**Traffic Flow figures**

**Traffic flow not presented to public consultation**

**Difference in figures**

Drawing Title: FIGURE 11.7 OPERATION PHASE DO MINIMUM OPENING YEAR DAYTIME NOISE LEVELS

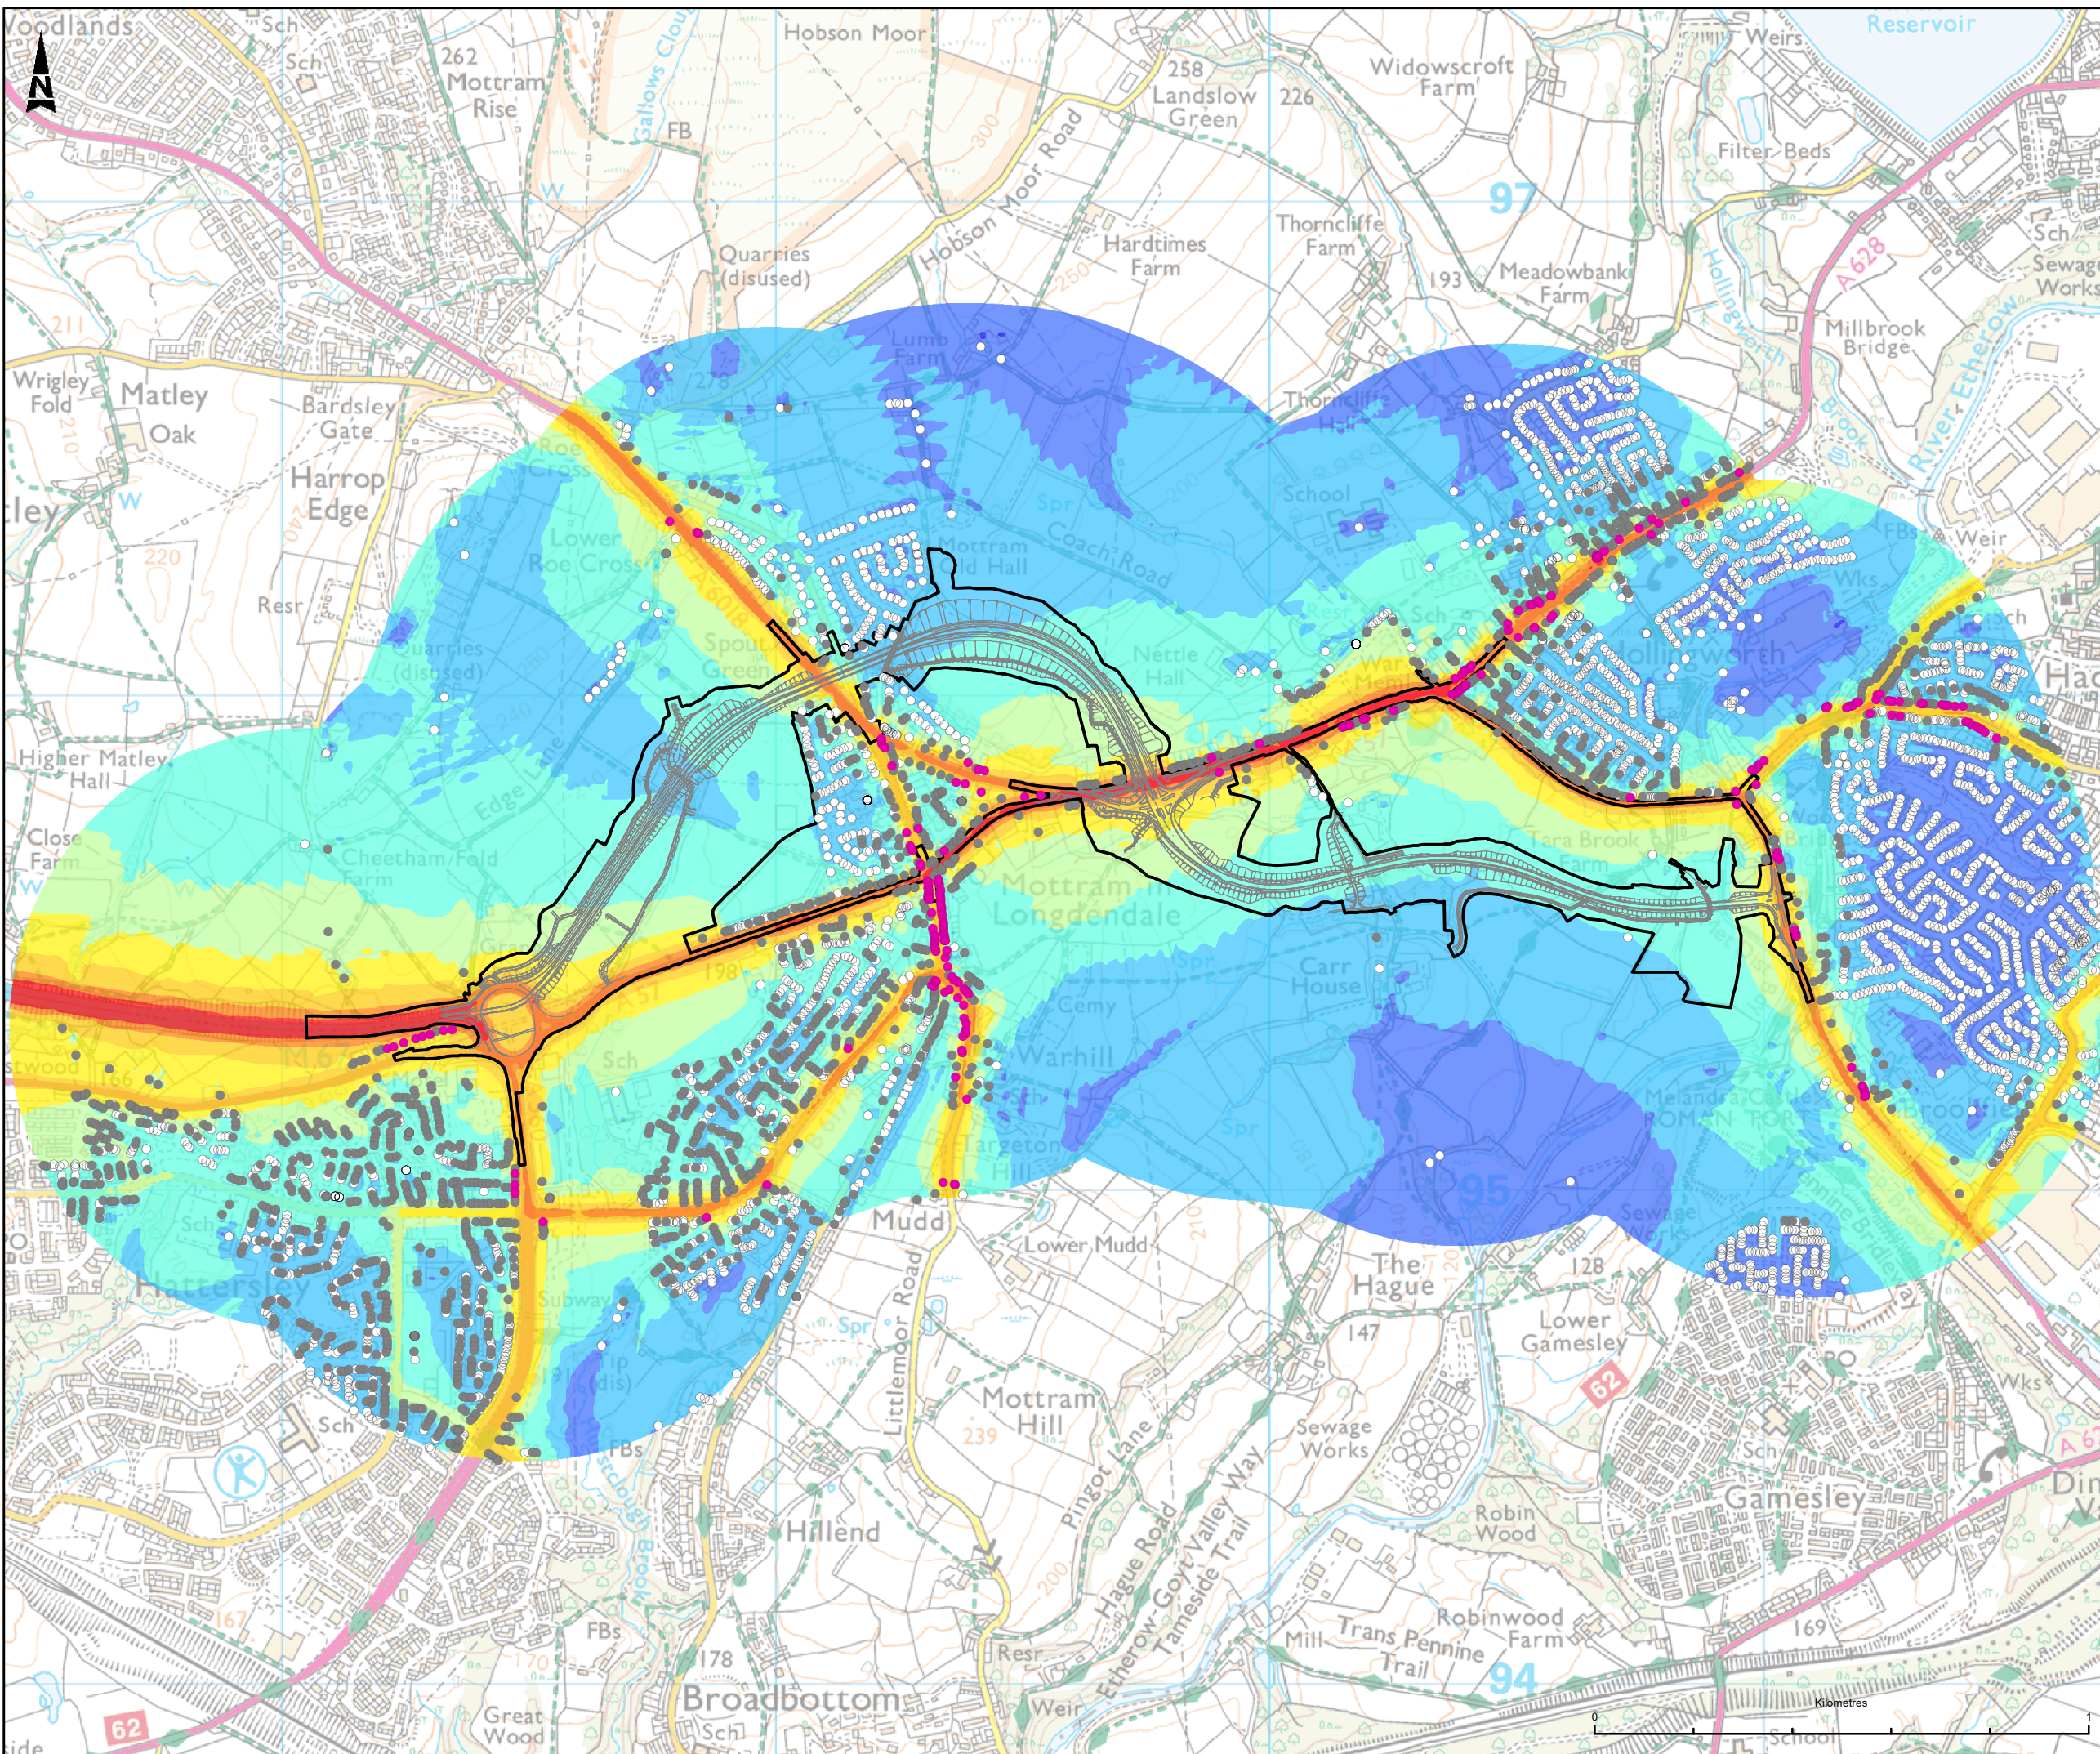
**Noise pollution from embankment to rear of our property**

For the first time in any document from Highways England there is mention of the noise pollution to the rear of the properties on the north of Mottram Moor from the embankment.

The mitigation measure is 2.5m high noise barriers on the embankment which is positive, but there is no description of what they are. We are assuming that they are 'timber fencing' like those used at the junction of the Airport Eastern link road and the A523 in Hazel Grove (see image). If this is the case then they will have a detriment impact on the visual effect from the rear of our property which could be reduced by staining the timber green.
